ENG-SF19004-R4-FDR-Redlines. Summary_Markup Summary

ENG-SF19004-R4-SC-CDs-Redlines Summary_Markup Summary

LOTS 36-41 STORM SEWER (PRIVATE)
SCALE 1"=30'

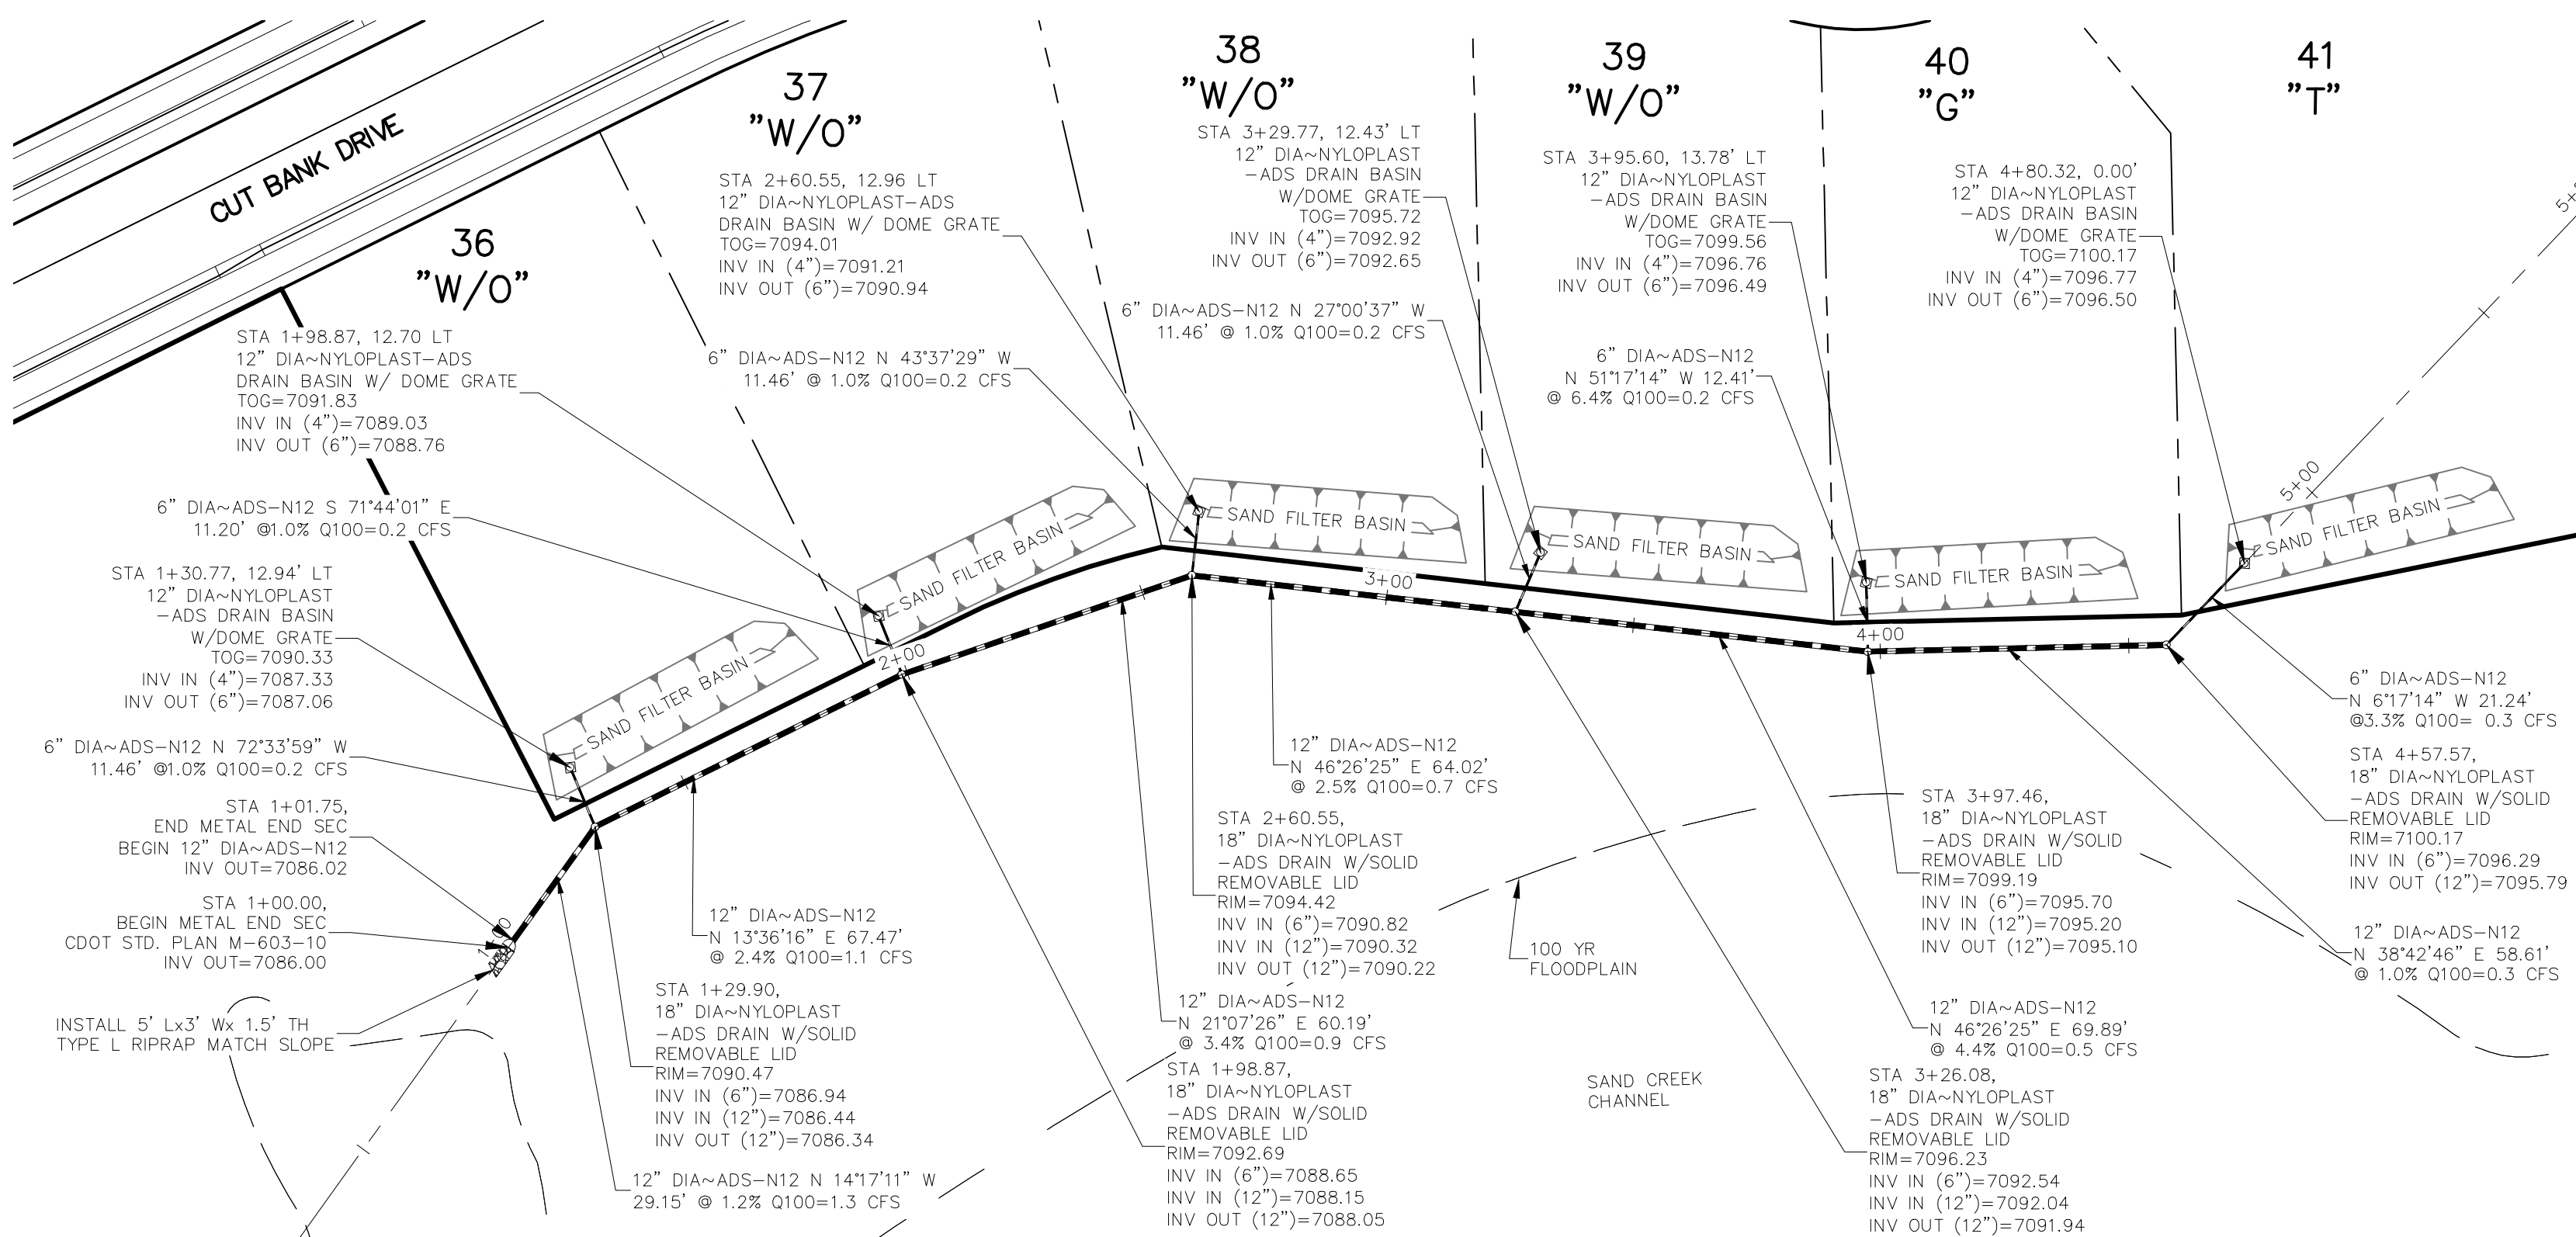
Add a more specific detail for the 52 SFB's that will be used for back yard WQCV. Since all 52 will be similar, provide the outlet structure detail, the outfall pipe sizing information, Fencing, (Split rail fence), etc.
